Our ref: DOC25/973133-4

**EPA Advice on Environmental Impact Statement – Aussie Skips Recycling – Bellfrog St
Site Upgrades – SSD-67497708**

I am writing in response to your request for the NSW Environment Protection Authority (EPA) to review the Environmental Impact Statement (EIS) for the proposed Aussie Skips Recycling - Bellfrog Street Site Upgrades (Application SSD-67497708) at 13 Bellfrog Street, Greenacre (the Premises).

Figure 7.2 Daily-varying cumulative 24-hour average PM₁₀ concentrations – R16 – Busy day - Scenario 1

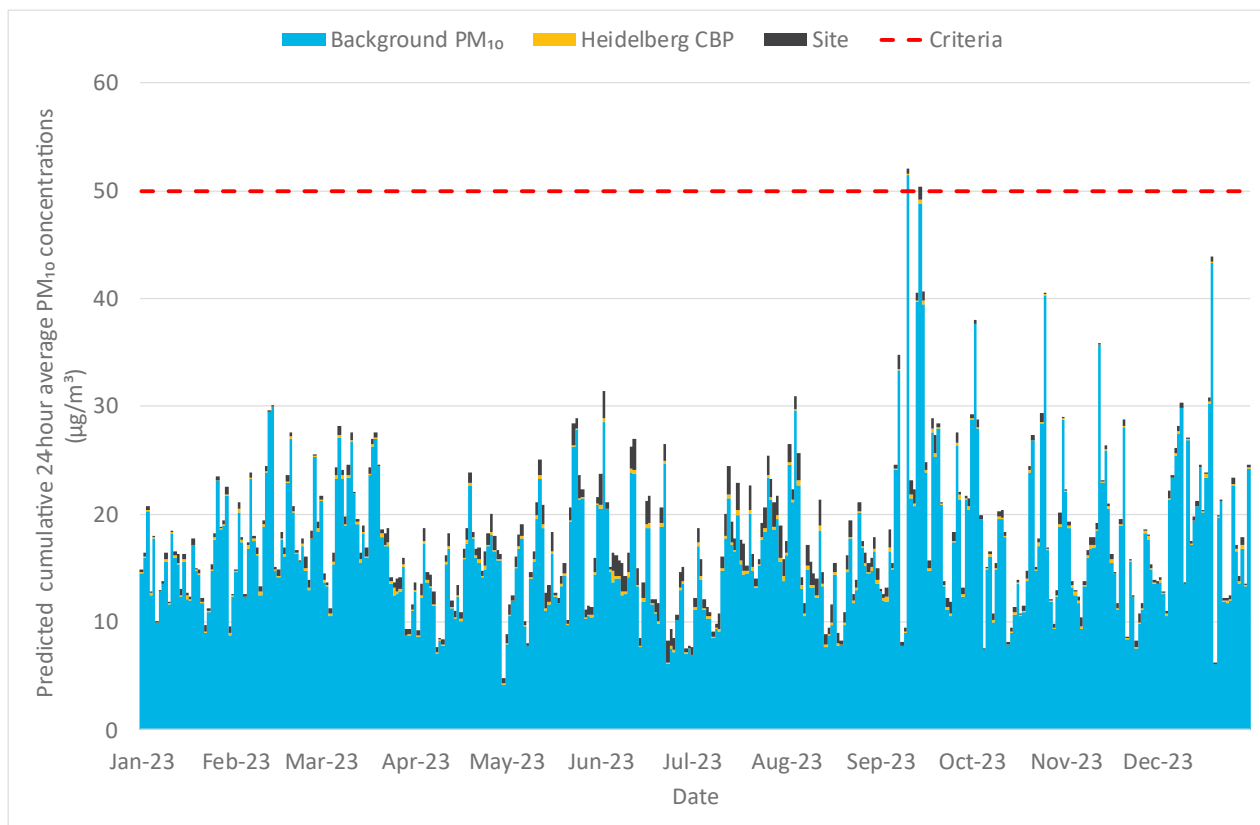
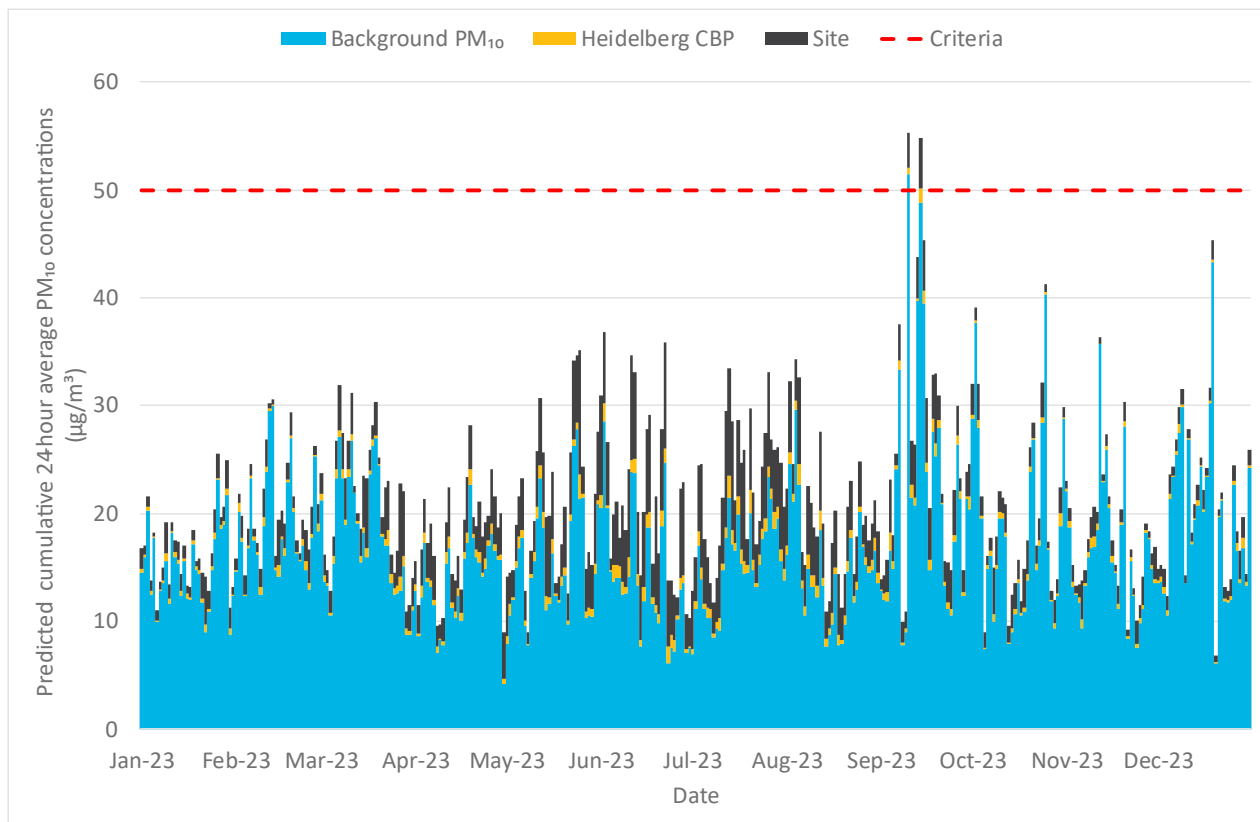
Additional PM₁₀ (24 hour) exceedances are predicted.

The AQIA predicts one (1) additional exceedance of the PM₁₀ (24 hour) impact assessment criteria of 50 ug/m³ at residential and industrial receptors. The predicted exceedances are found on days where existing air quality accounts for between 82% and 98% of the predicted exceedance.

Table 7.3 of the AQIA presents the cumulative ground level concentration (glc) for the proposed design of the project for 'busy day' operations. The cumulative ground level concentrations account for emissions for the proposed project, existing background air quality, and the Heidelberg Materials site. For the assessed industrial receptors, a maximum PM₁₀ glc of 54.8 ug/m³ is presented, and for the residential receptors a maximum PM₁₀ glc of 51.3 ug/m³ is presented. The AQIA outlines that one (1) additional PM₁₀ exceedance is predicted. Figures 7.2 and 7.3 show the contributions from existing background, the proposal and the Heidelberg site. The contributions from the proposal to the additional exceedances have not been provided in tabular form to understand more specifically the actual predicted contributions.

Section 8.4 of the AQIA outlines a commitment to using real-time particulate matter monitors at the site. The monitors are proposed to be used to inform a trigger action response plan (TARP) to facilitate reactive management of particulate matter emission from the site. Further detailed information is requested to demonstrate how the proposed monitoring and TARP could manage the predicted PM₁₀ exceedances.

- (a) Include numerical glc contributions from the premises to the predicted PM₁₀ exceedances.
- (b) Demonstrate how a proposed trigger, action, response plan could prevent the predicted additional PM₁₀ exceedances. The demonstration should include presentation of predicted glcs (site contributions and existing background) accounting for potential triggers and actions that could be implemented into the TARP.
